## Pre-application advice letter from Hillingdon Council, 12 February 2024 – Response notes

Item	Page	Comment	Response
<b>1.</b>	4	<b>Principle of Development</b>	
1.1	5	It is requested that the relevant parts of the Metropolitan Police Estates Strategy, which outline their alternative strategy for Northwood is submitted	<p>The current site owner does not have any access to the Metropolitan Police Estates Strategy. Nonetheless enquiries have been made of the Metropolitan Police and they have responded as follows:</p> <p>“Unfortunately we are not able to comment on the specifics of your proposed application and will leave the local planning authority to comment on the merits of it or otherwise. The current draft estate strategy is yet to be approved by MOPAC and therefore cannot be released for submission in support of this application. I do however attach two documents that may assist. Both documents are in the public domain;</p> <ul style="list-style-type: none"> <li>i) The MOPAC/MPS Public Access Strategy 2017. This document sets out the MOPAC/MPS strategy for public access confirming which police station front counters will be closed and buildings disposed of. The document also

Site Layout Plan

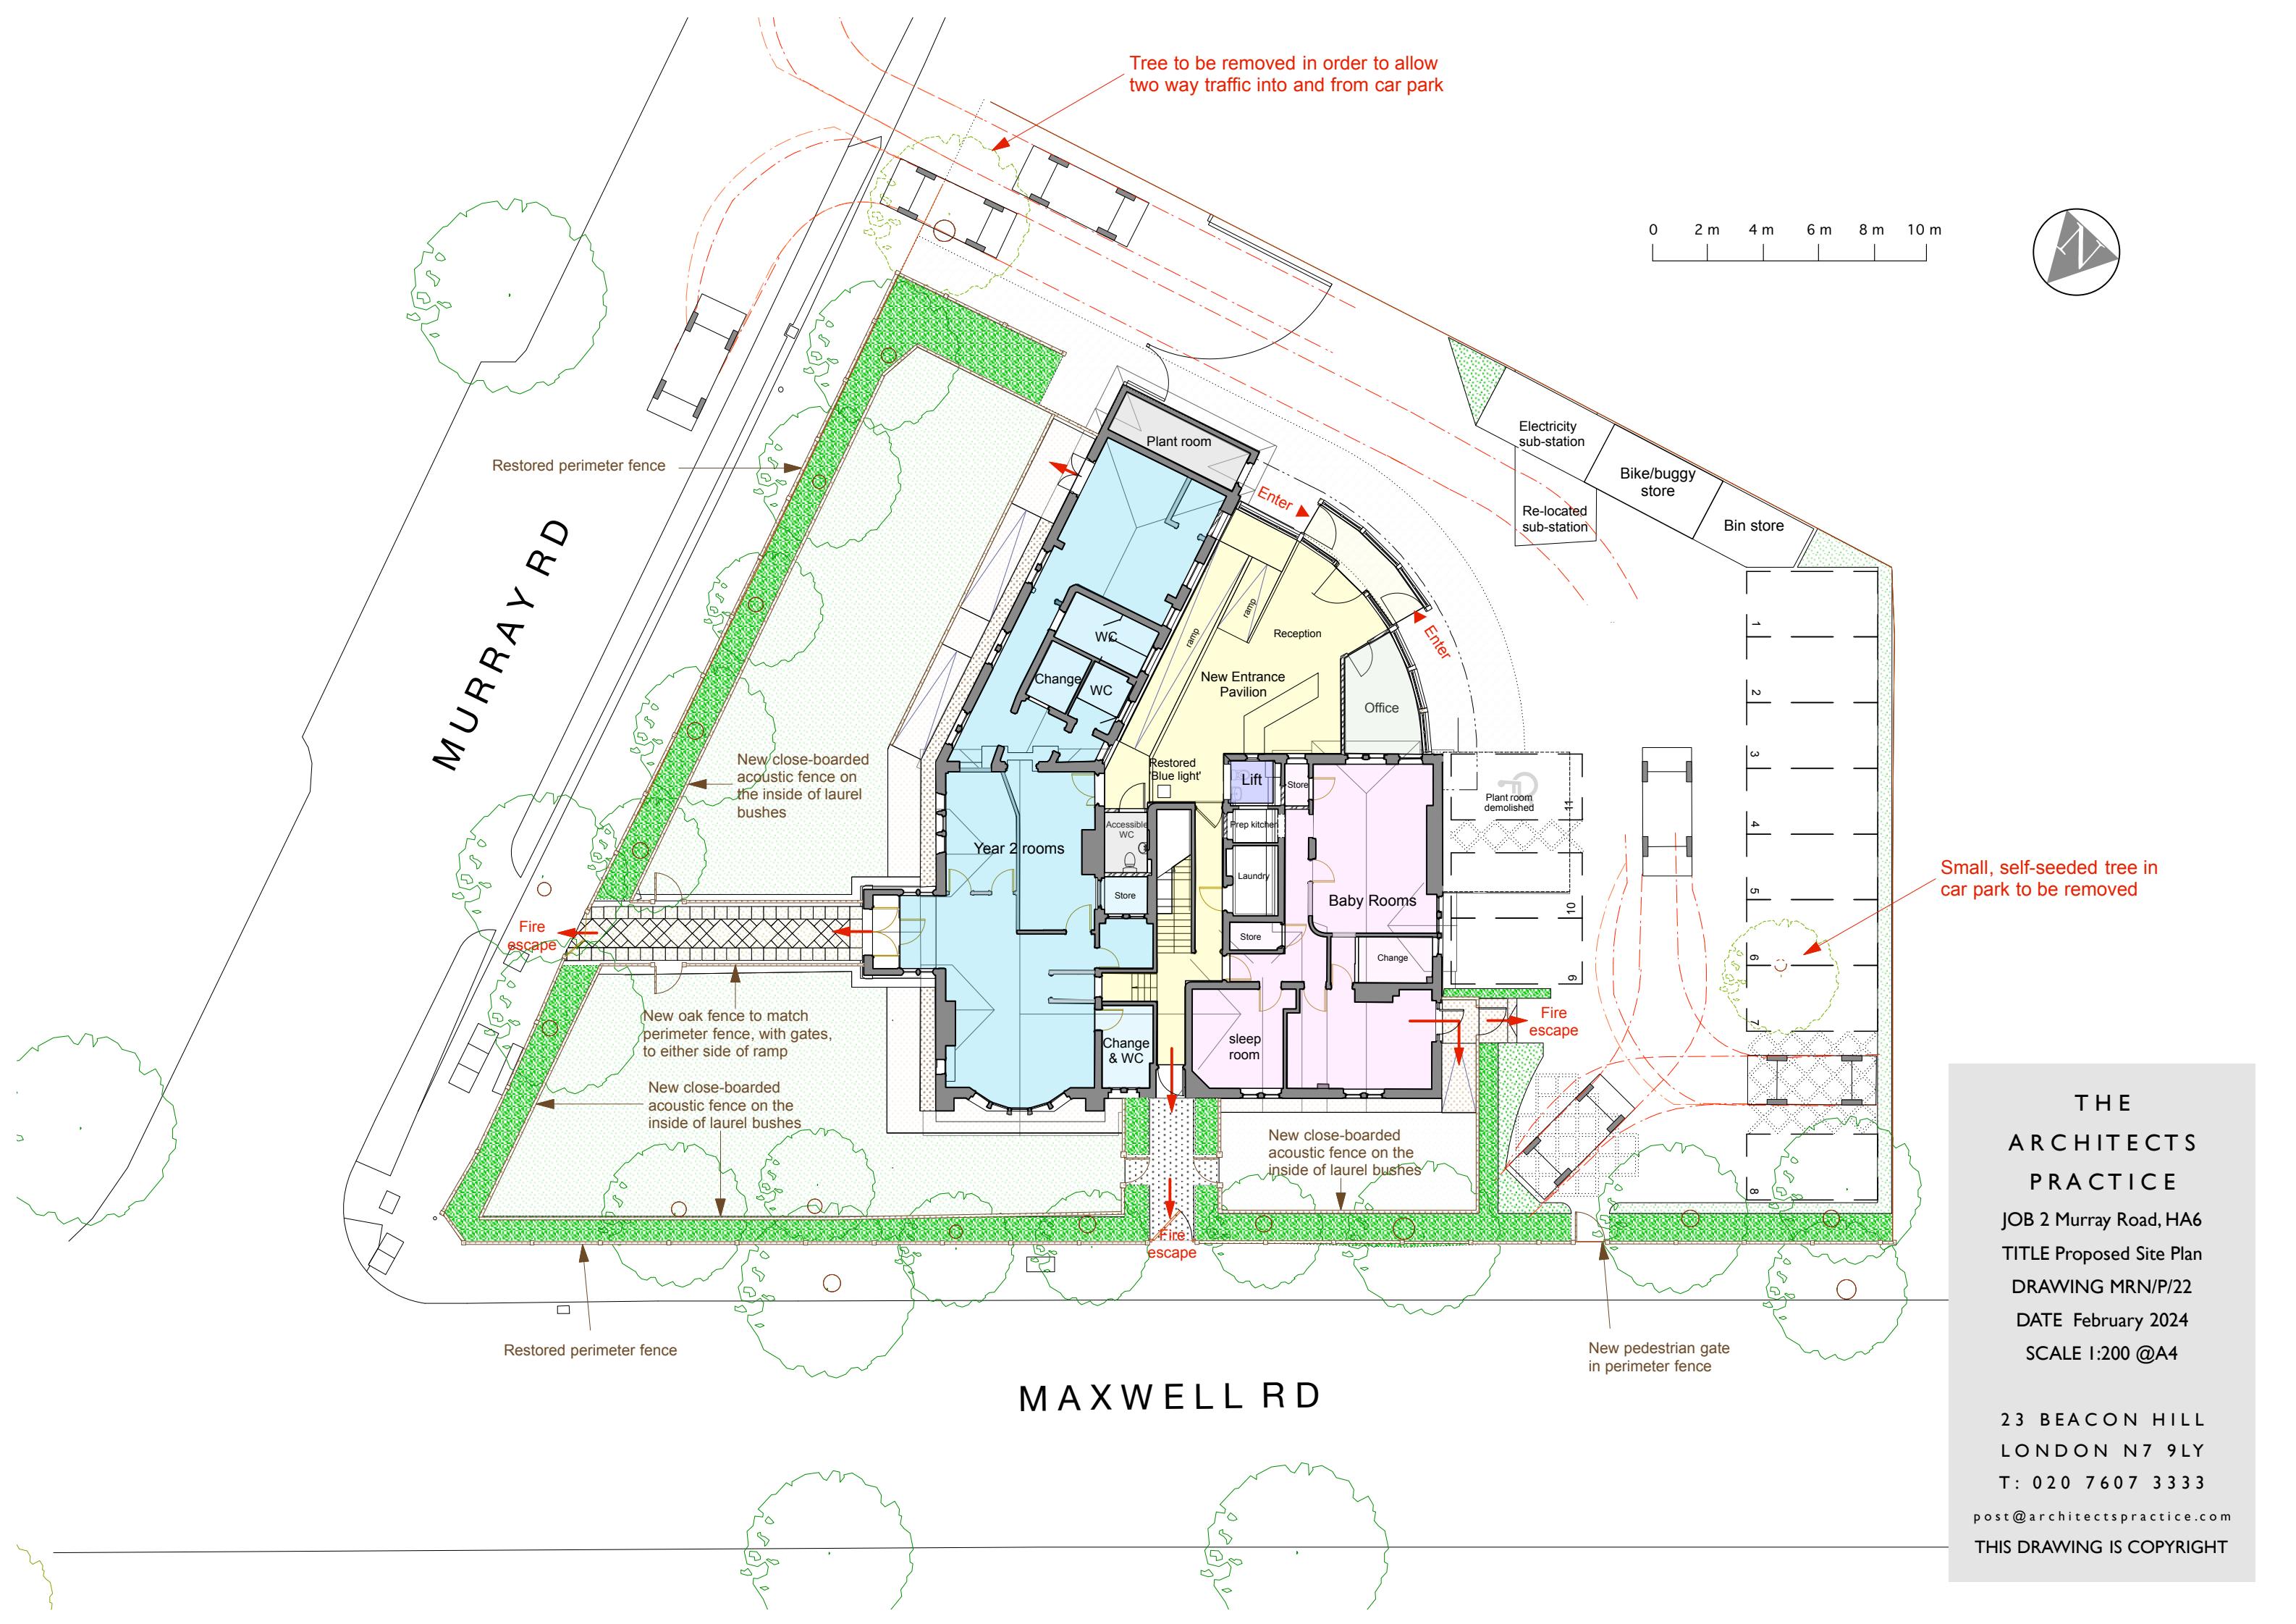
4.3	11	Evidence of 'swept path' analysis should be integral to any future submissions ... It is noted that such an exercise has already been presented.	Confirmed The swept path analysis has been updated along with the minor changes to the car park layout

Access and Visibility

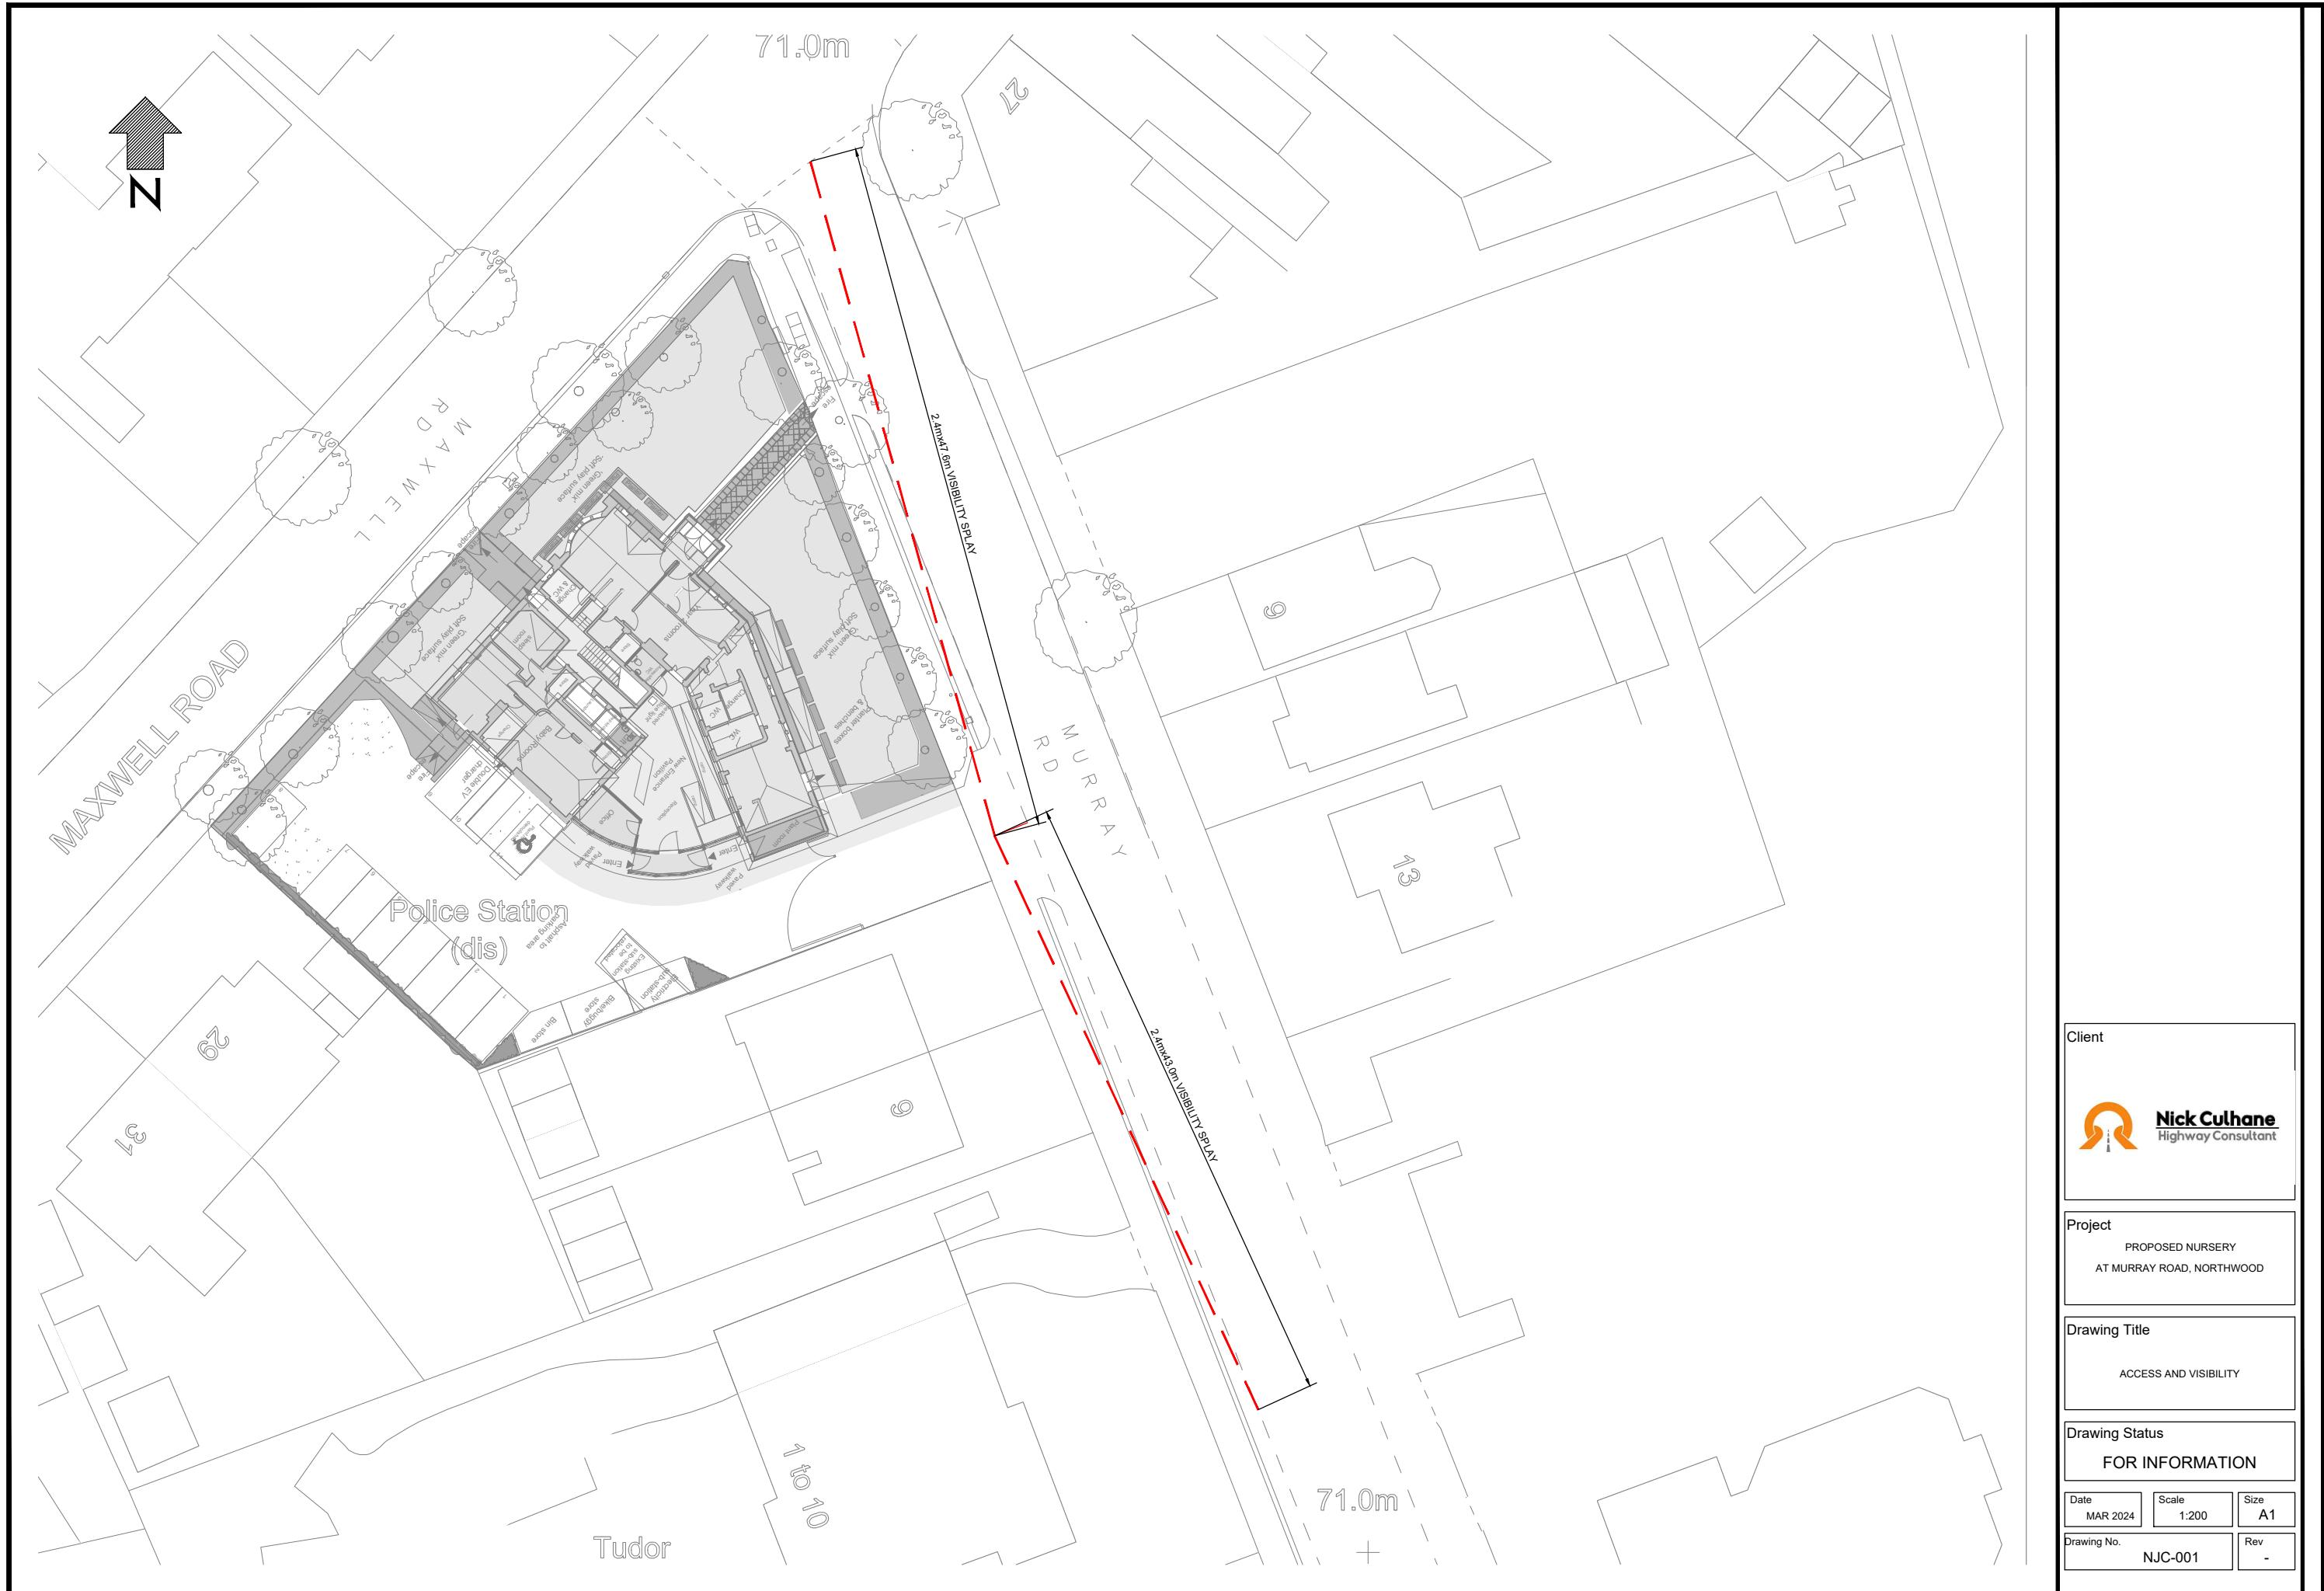
4.5	11-12	Satisfactory highway visibility splays at this established access point is also considered necessary and should be applied on pedestrian & vehicular safety grounds. There should be demonstrated conformity to the relevant mutual inter-visibility sight-line requirements, as per DfT (Manual for Streets (MfS) circa 2007) best practice for new development road and parking layouts guidance, between vehicles leaving the site and extraneous vehicles/pedestrians using the surrounding road network. It is therefore recommended that a lower height of frontage boundary treatment is applied in proximity of the access.	Drawings showing highways visibility splays in conformity with the Manual for Streets (MfS) requirements are included in the application documents
